Rolling Hills Ranch at Meridian Ranch  
 Filing No. 2  
 Transportation Memorandum  
 (LSC #194182)  
 \* August 27, 2020

# Summary of Comments on [WORKING COPY] TIS Redlines DEC 2020 - Pages from Traffic Impact Study\_v2 1.pdf

RE: Rolling Hills Ranch at Meridian Ranch  
Filing No. 2  
El Paso County, CO  
Transportation Memorandum  
LSC #194182

Figure 3
Existing Traffic, Lane Geometry,
Traffic Control, and Level of Service
Rolling Hills Ranch Filing 2 (LSC #194182)

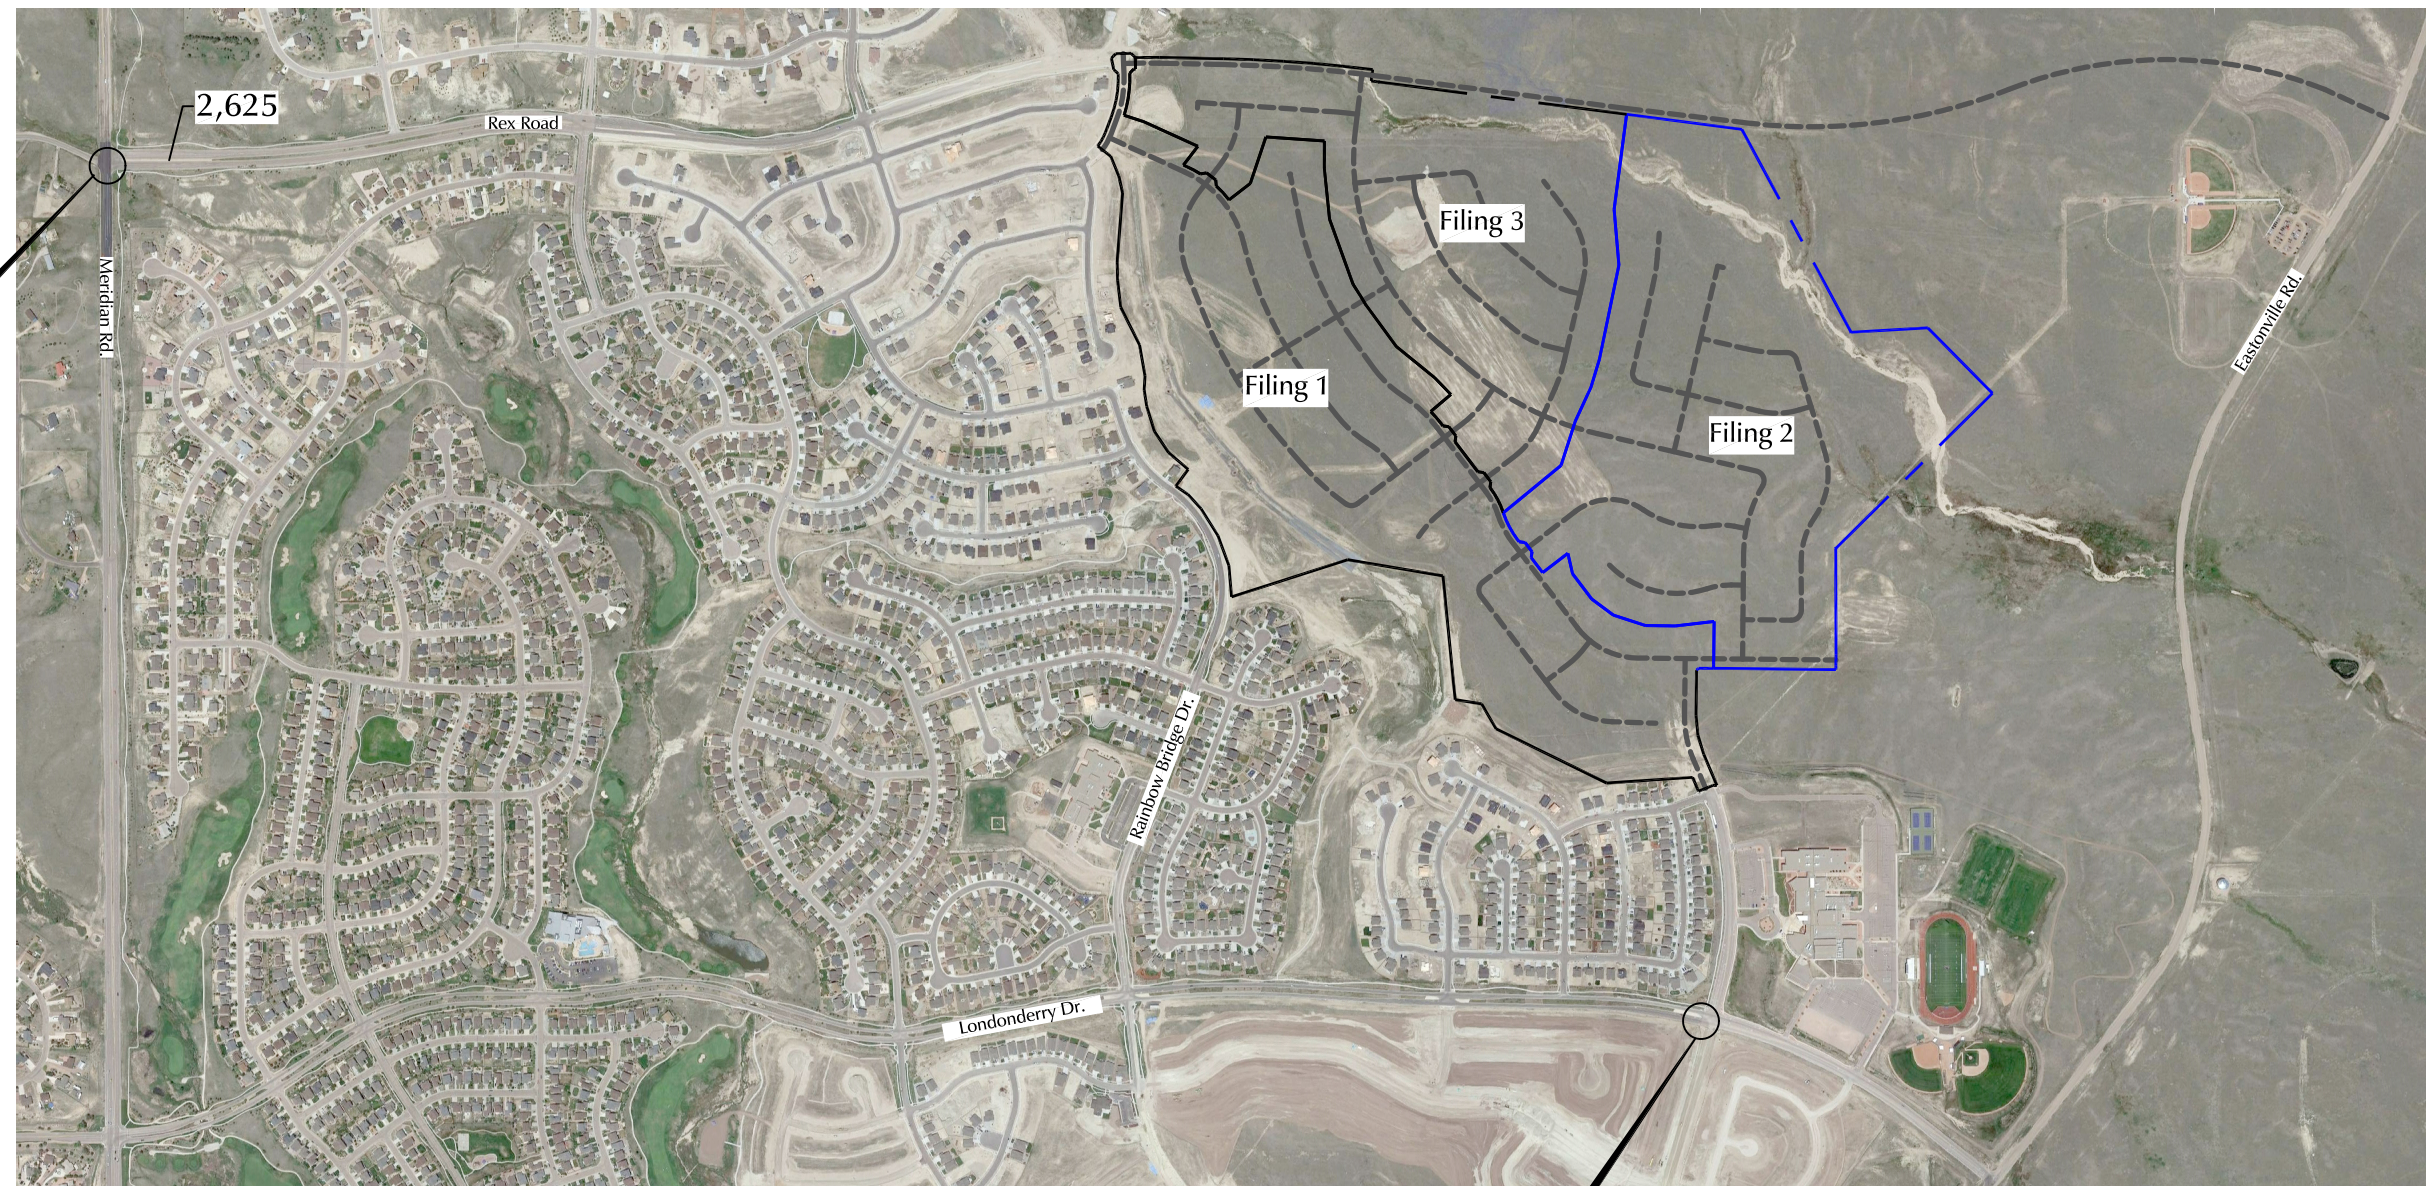
Please provide a description of the existing lanes/turn lanes at this intersection.

LSC Response: The requested information has been added to the updated report

Figure 19

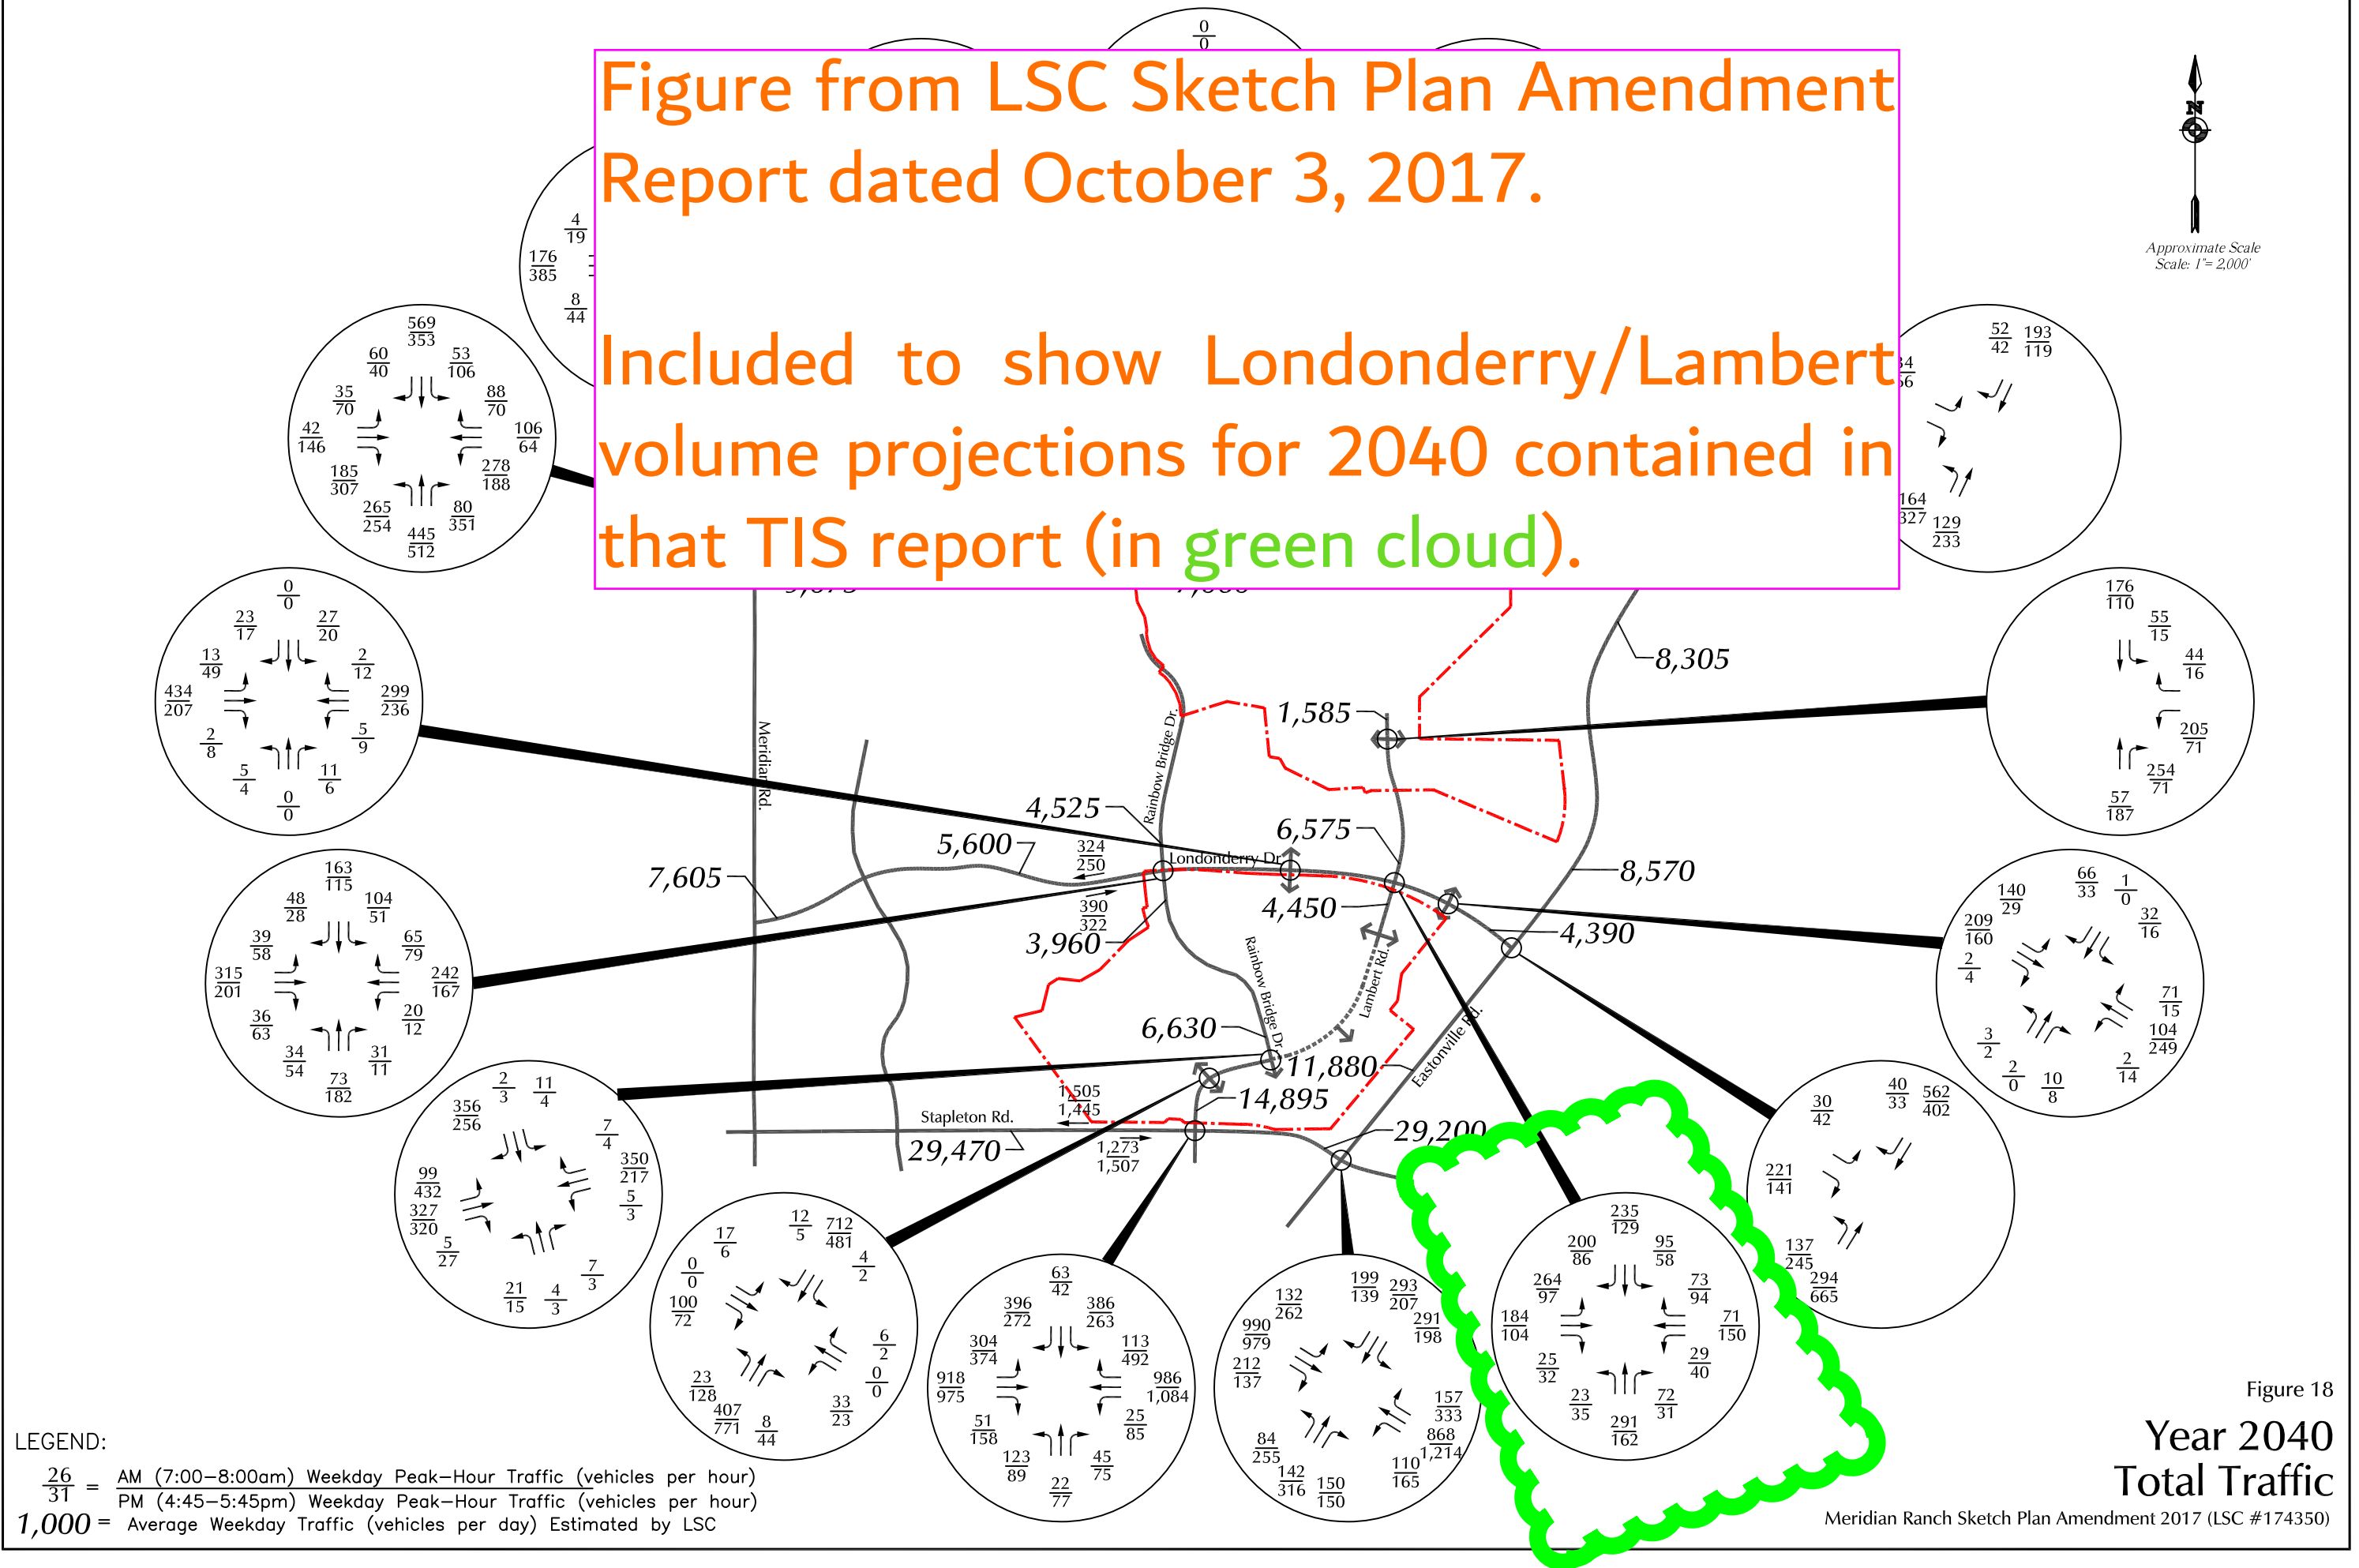
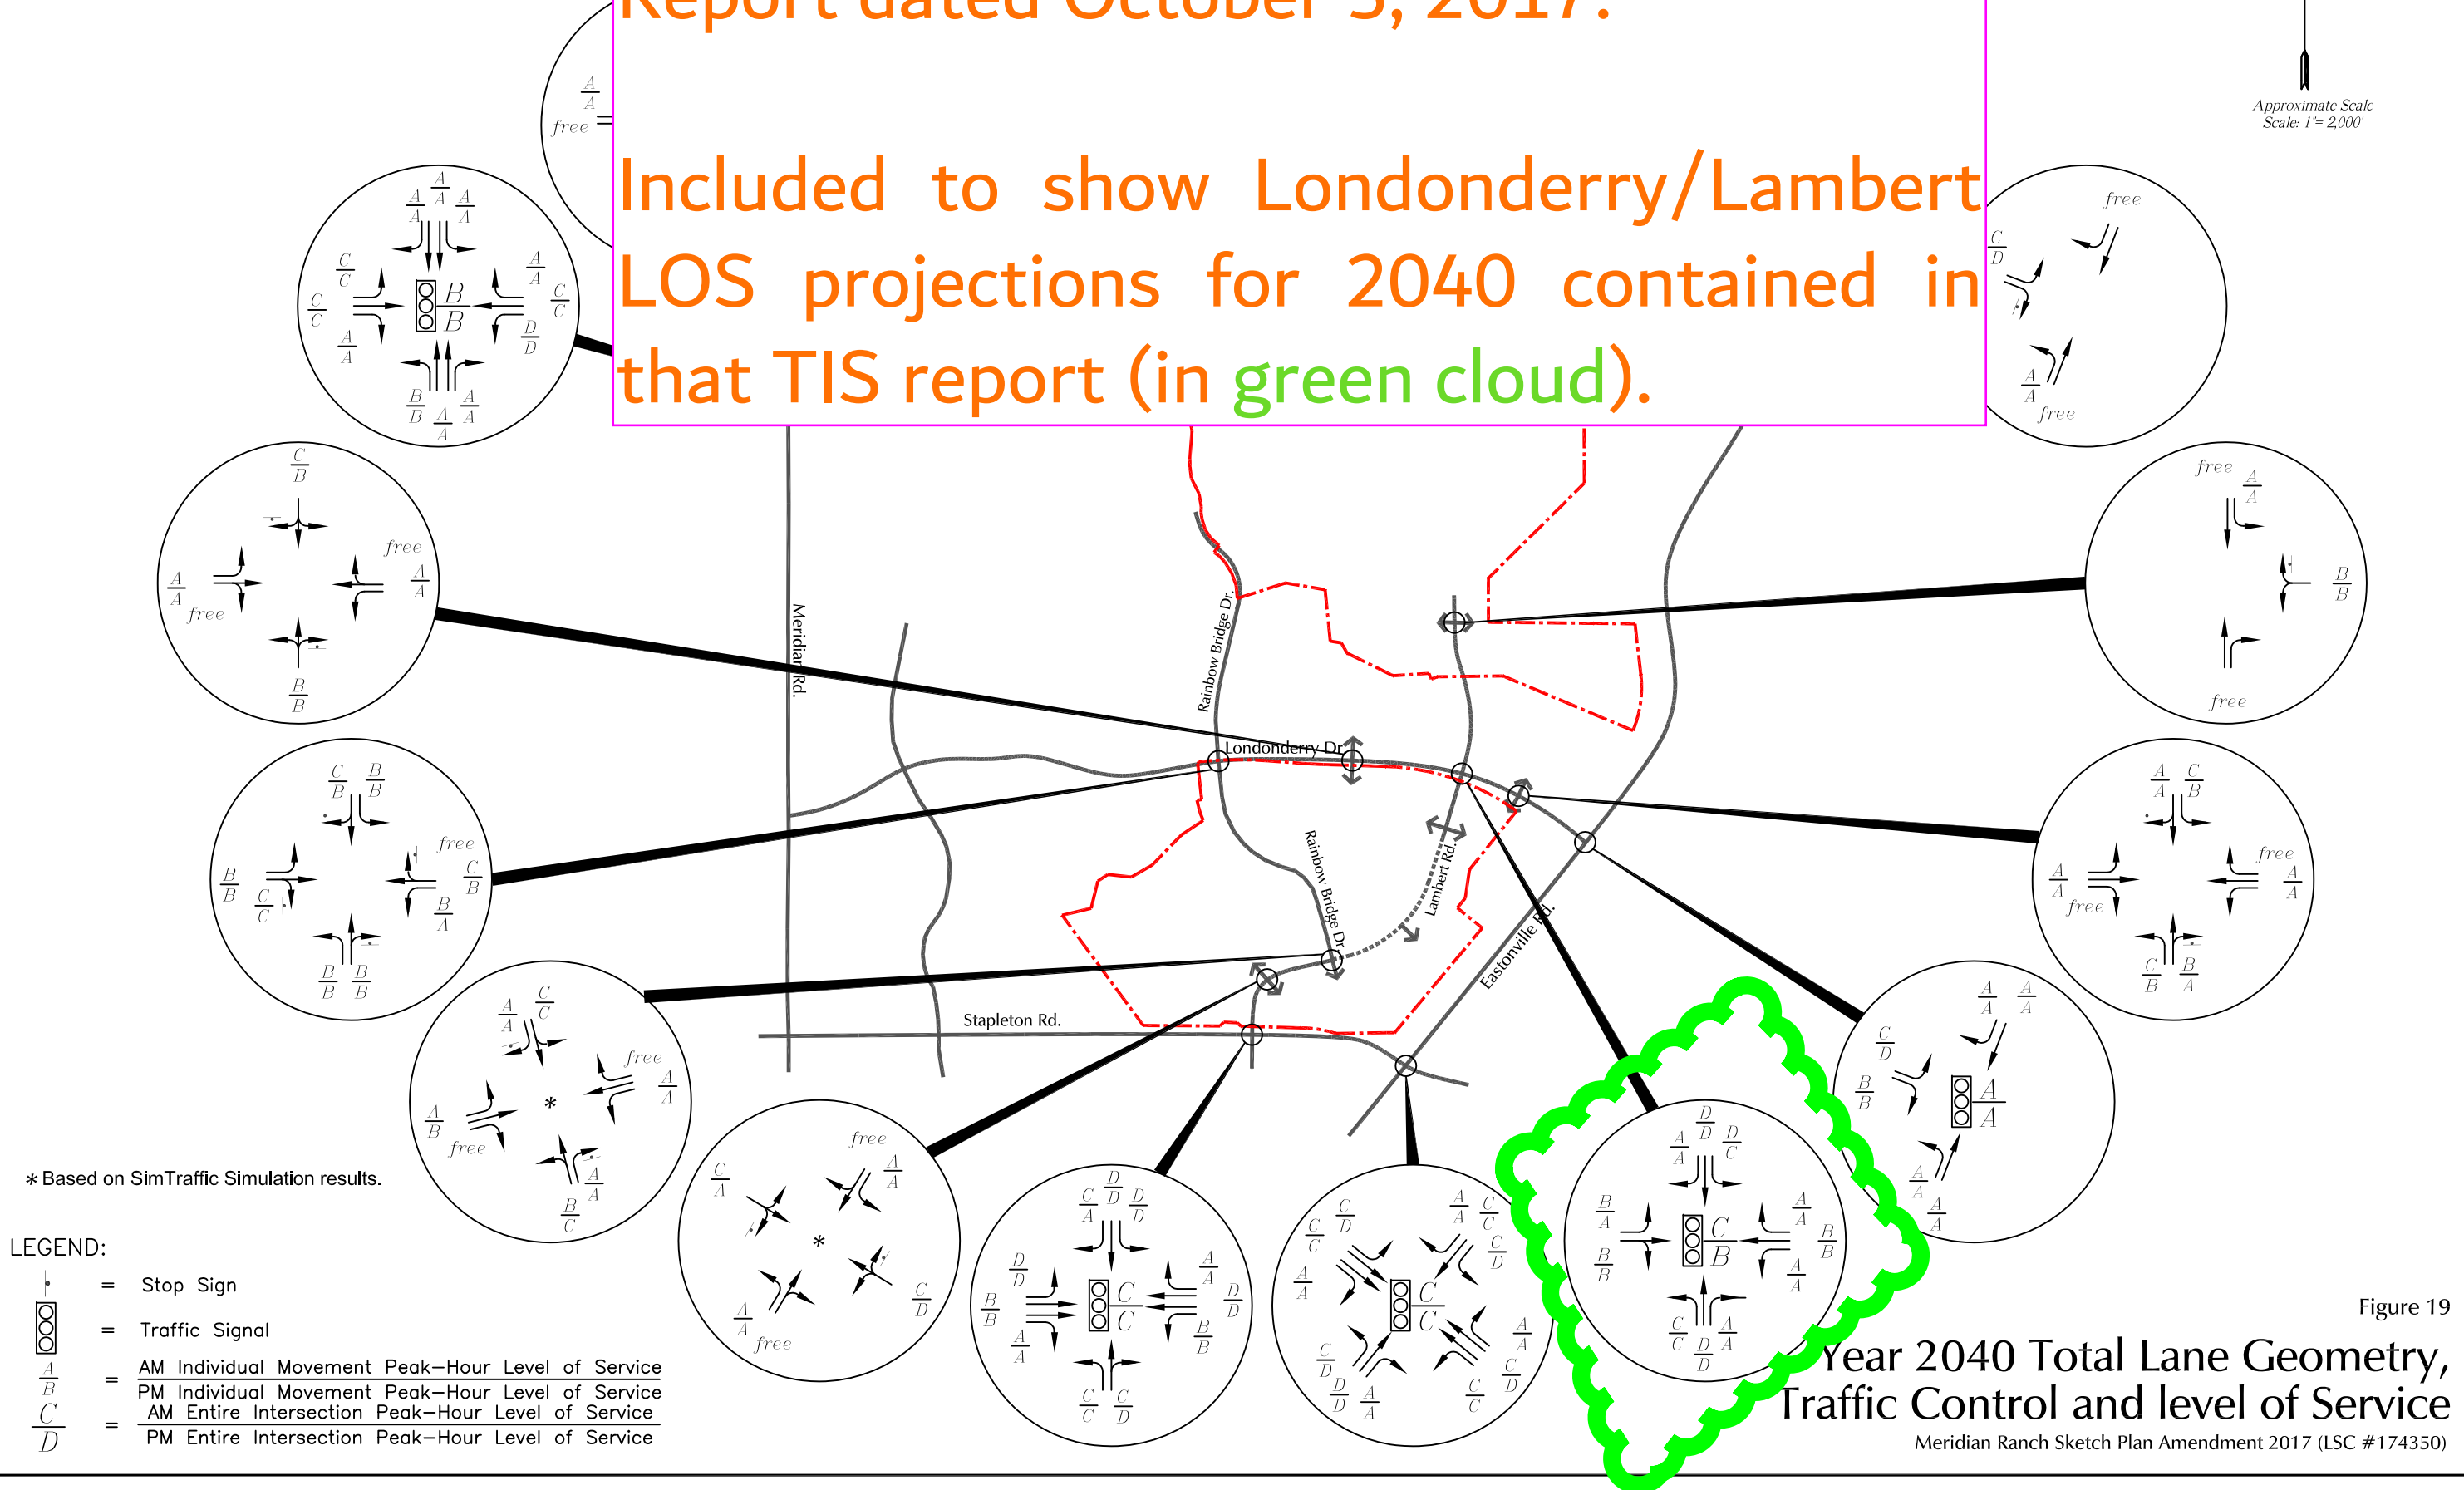
2040 total traffic volumes and LOS were not provided for Londonderry/lambert. Please provide.

LSC Response: Key pages from the Meridian Ranch Sketch Plan 2017 Amendment Traffic Impact Analysis that address the 2040 total traffic volume and LOS for the intersection of Londonderry/Lamber are included with the updated report
